Reference: Planning Application No 20/11388 & 20/11387

We have received your notice of a planning application regarding the walled garden owned by our neighbours at Dodington House, The Marsh, Breamore SP6 2EJ. Having reviewed the proposed plans to replace the current menage located at the rear of our property, with a tennis court, complete with a new building housing changing rooms and storage facilities, together with a large, gravelled area set aside for the parking of motor vehicles. We are extremely concerned if granted the proposed development will be used for non-domestic use, so we are registering our **Strong Objection** to the proposal based on the following points.

ELEVATIONS 1:50  
NEW CHANGING ROOM & STORE

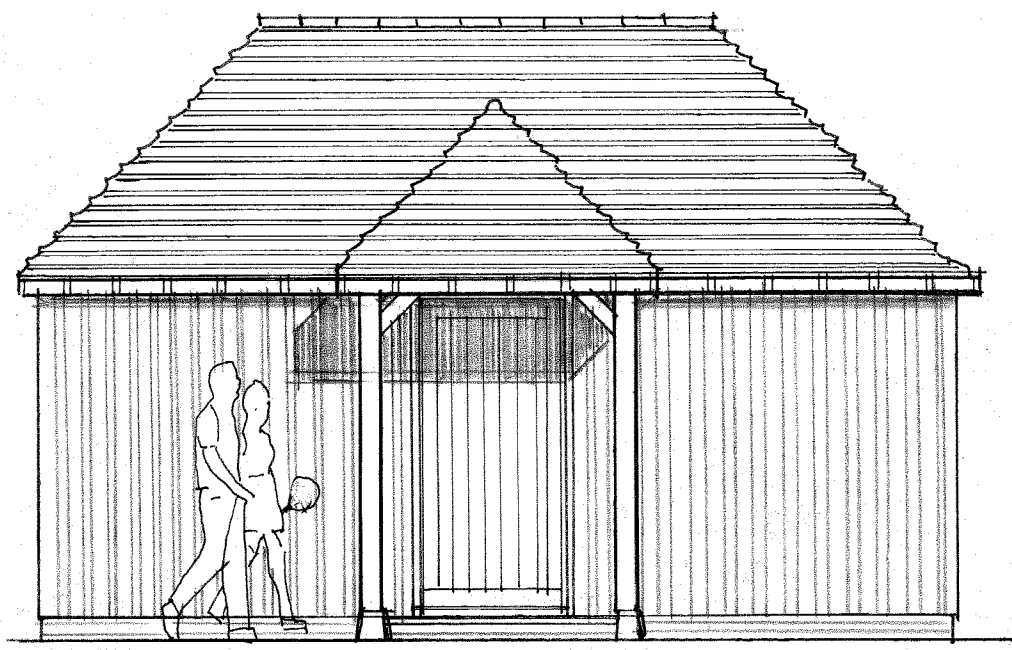
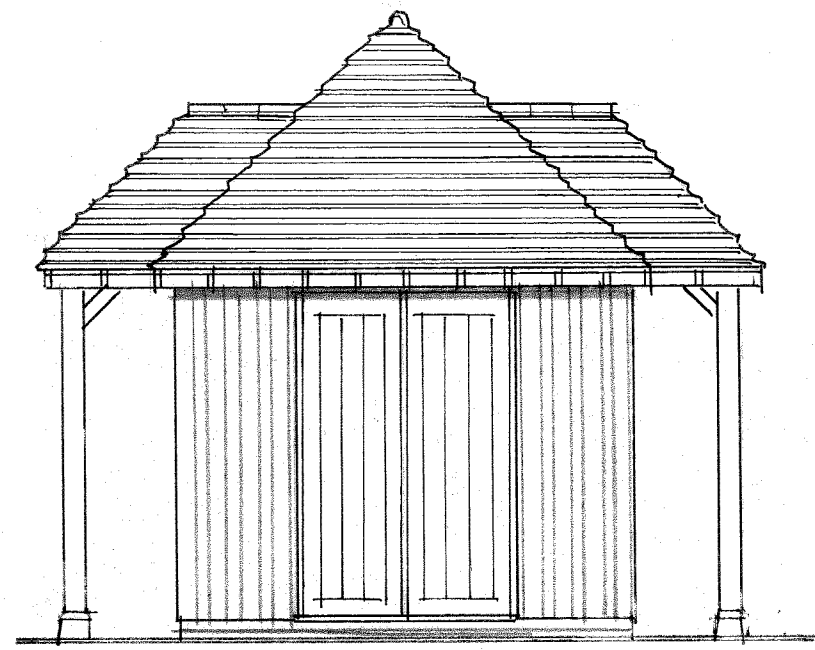
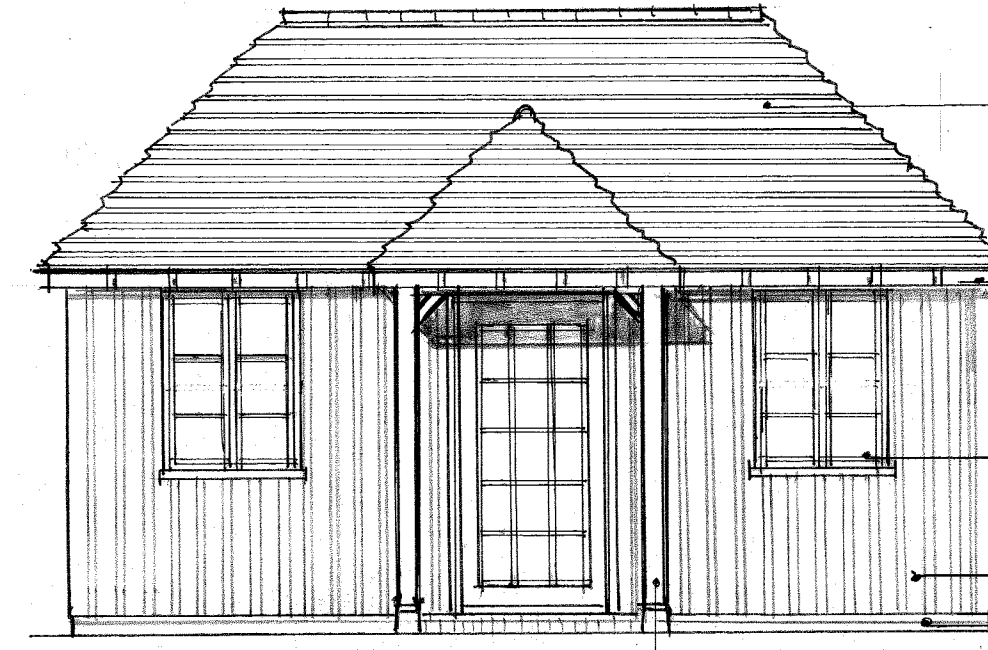
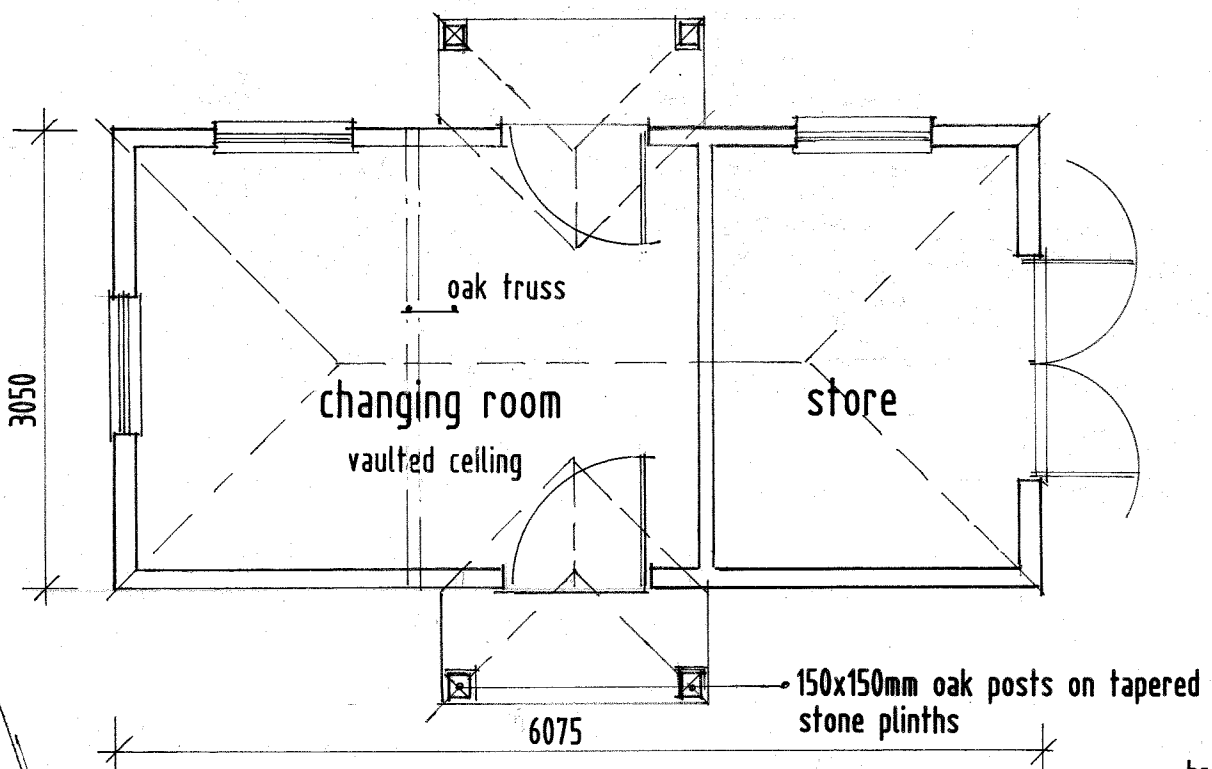
- a. The planned car parking gravelled area appears to be designed for a minimum of 15 vehicles at one time (taking scale from the application drawing) This, together with the planned construction of a substantial 6m x 3m changing room and store of considerable height which is visible over the line of the current wall, and chain link fencing would suggest that the facilities are not intended for purely residential use, but are more suited to a sports club or public/commercial/non domestic use and are therefore likely to result in more frequent and increased traffic flow via Rectory Lane. If it were for domestic use, surely a car park would not be necessary at all. There is a very large parking area at the front of Dodington House where family/friends and visitors of the applicant would normally park, which raises a lot of concerns as to why further parking would be deemed necessary and included in the planning of a domestic tennis court, alongside a large changing facility and store.

SITE PLAN AS PROPOSED 1:200

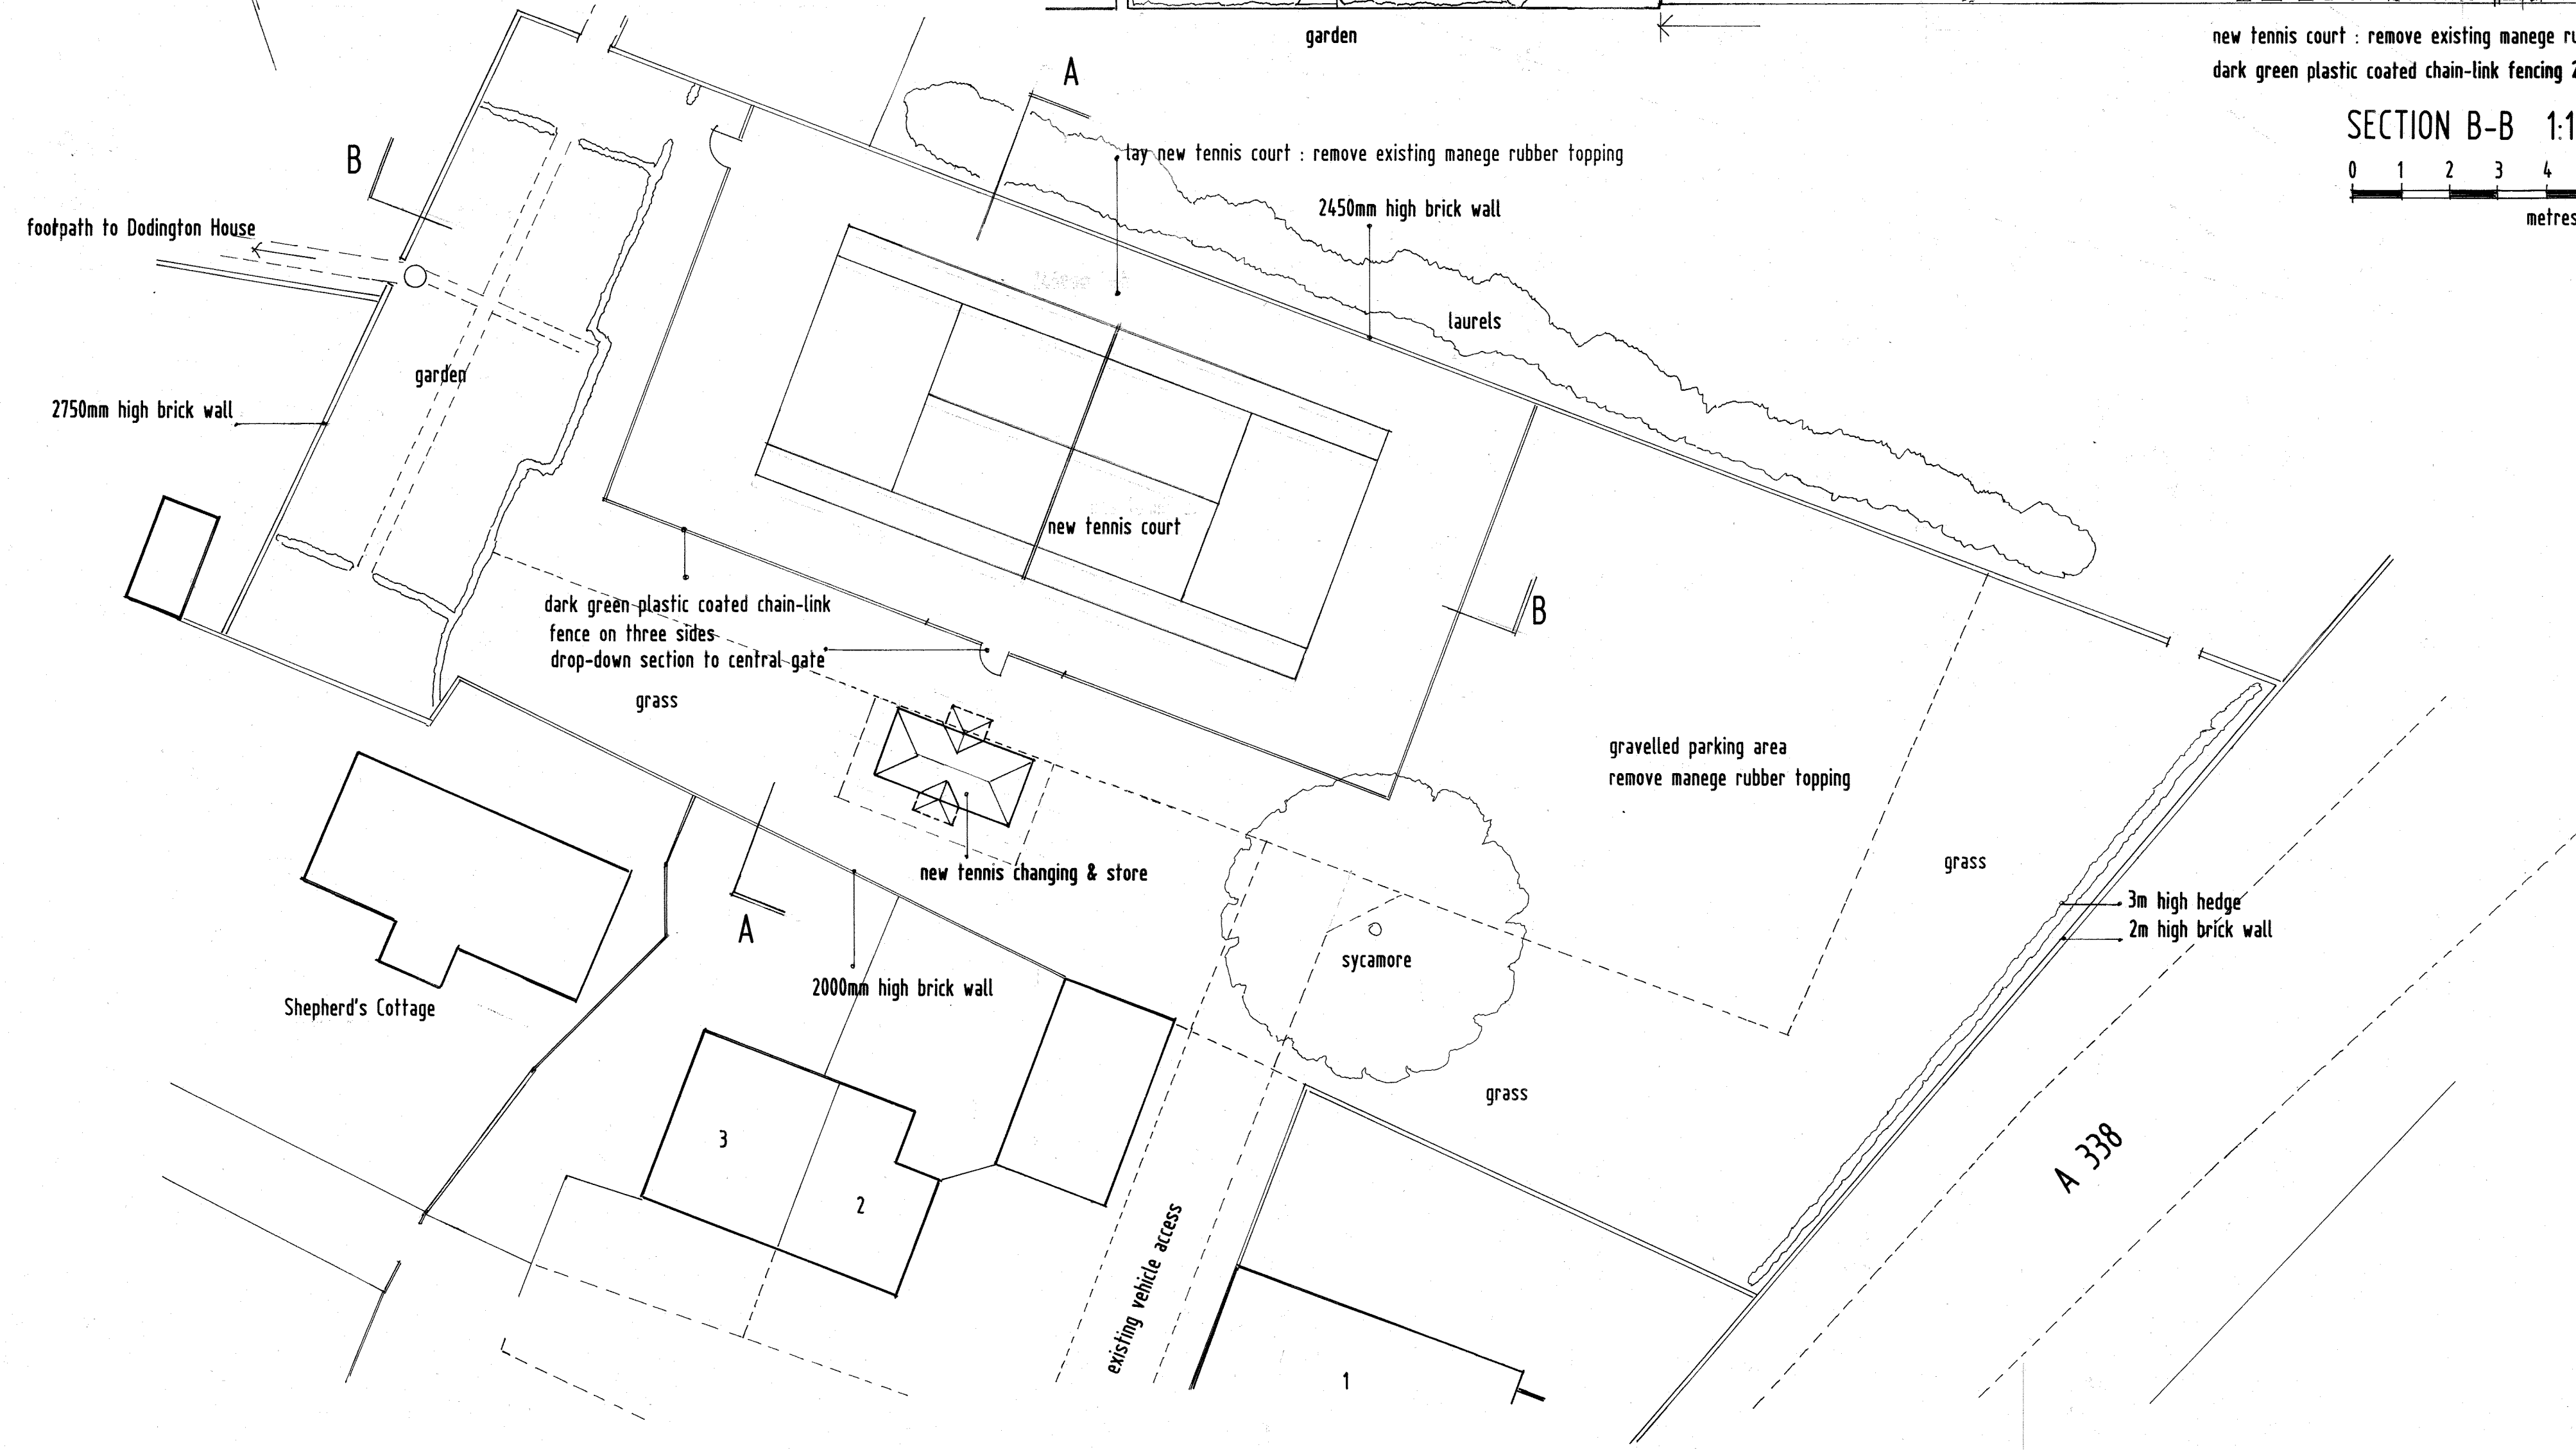
- b. The proposed gravel car parking area is directly in view from our bedroom windows which would be unsightly at best to look at. It totally alters the scene and landscape we look out on. Our current view would be enormously altered from a manège to a car park full of cars coming and going. This is not sympathetic of the area in which we live or a view common to any of the houses in Breamore, which is a small rural village. The view would have an adverse impact on the rural character of the Breamore conservation area, but also adds to our air and noise pollution concerns particularly for our children in our relatively small rear garden which backs onto the walled garden.

- d. With parking facilities for upwards of 15 cars and therefore presumably for access to the public at the rear of our property, we have concerns relative to the increased security risk to our cottage and belongings, the privacy of our small rear garden, our privacy of our bedroom windows, and the safety and wellbeing of our young children stepping out of the front or side of the house due to increased traffic on Rectory lane,
